Subject: RE: White Cottage (WA/22/19/PL)

Further to your recent comments regarding the above application, please find attached a copy of revised drawing B16e for your approval.

Drawing B16b August 2018 Scale 1:20 & 1:100 @ A1
Building Regulation Drawing - Externals Plan

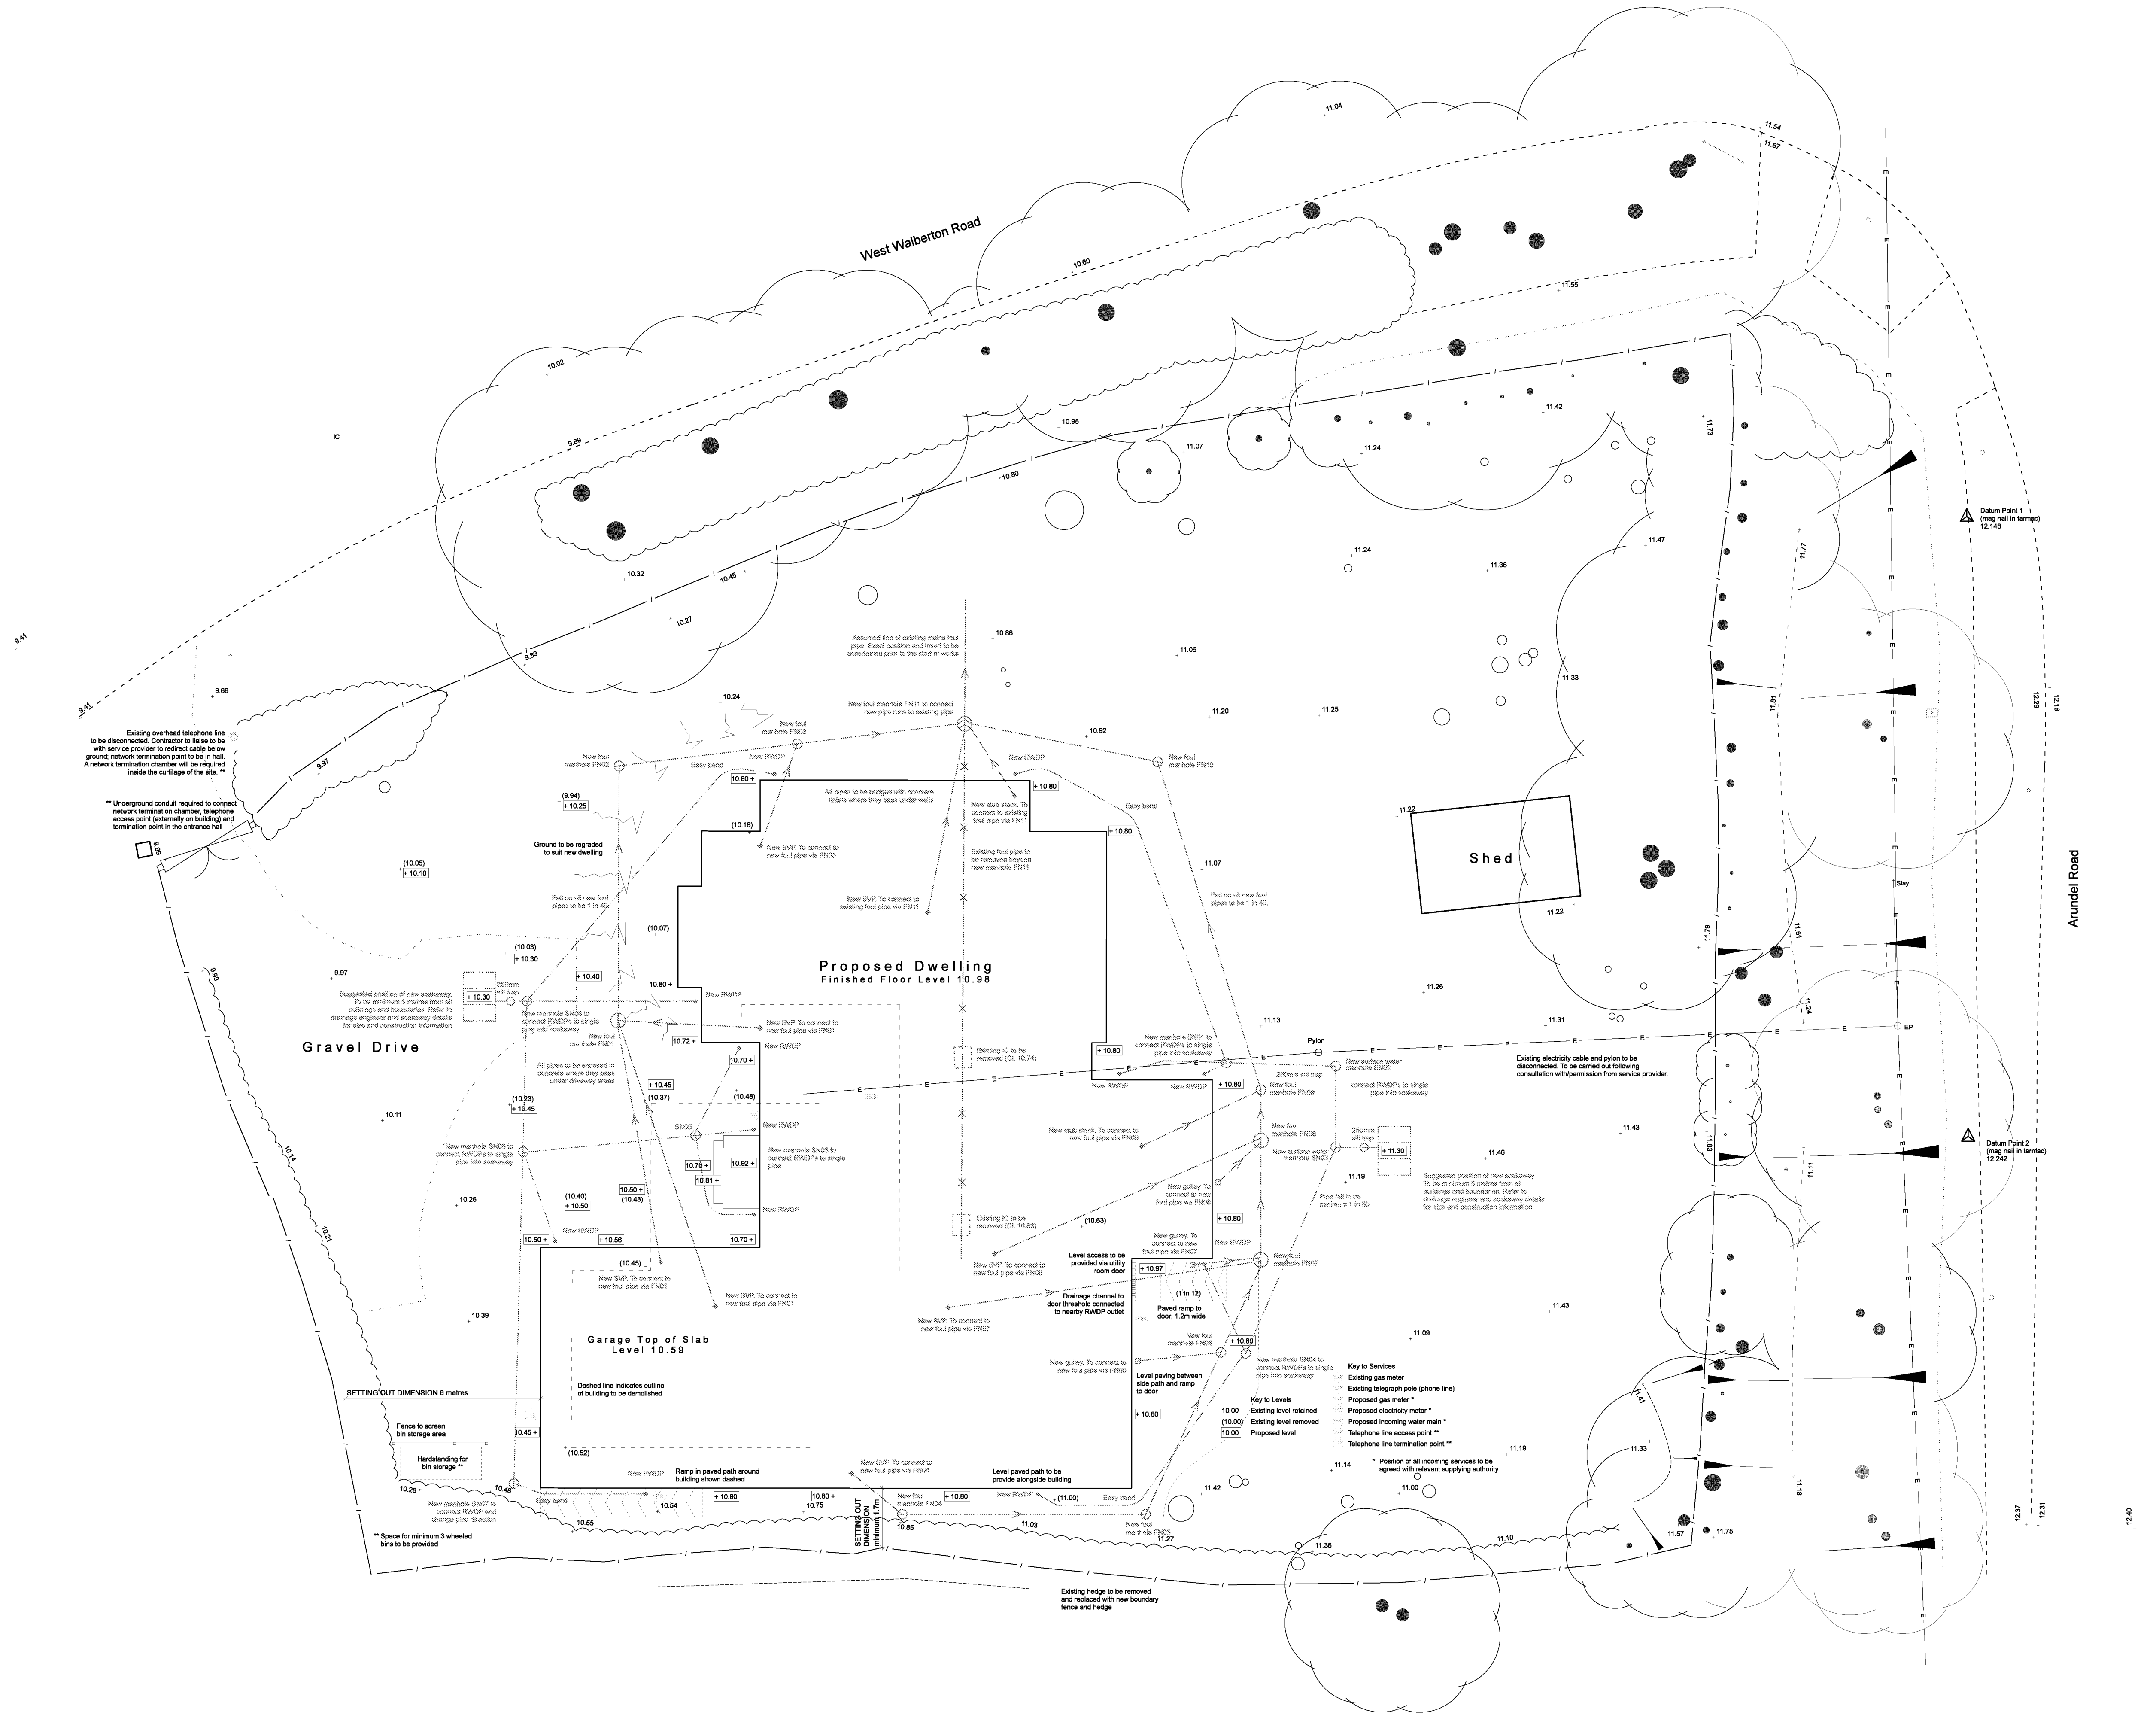
Thank you for the updated drawing. I appreciate that the extra level of crates have been included to compensate for the lower pipe level. However I am aware that this will provide a soakaway of capacity beyond design criteria which will result in additional expense to the applicant in excavation and materials. I am happy to accept this drawing and recommend removal of the condition, however if you supply a drawing with a soakaway of three crates depth I will also accept this. I asked simply that the pipe be raised to the highest point possible which I am happy that you have done.

An additional layer of crates has been added to the soakaways to ensure that the invert is at least 1.2 metres below the incoming pipe.

I have looked at raising the level of the incoming pipes; the length of the longest incoming pipe to the rear soakaway is around 20 metres. At a fall of 1 in 80 and with minimum 300mm cover over the pipe, it is not possible to raise the level of the pipe where it joins the soakaway.

Whilst the fall and pipe lengths for the front soakaway would allow the incoming pipe to be at a similar level to the rear soakaway pipes, a minimum 710mm cover is required over the crates as they are positioned below the driveway. Therefore the best I can do is to raise the pipe to connect to the top of the highest crate, as shown on the amended details attached.
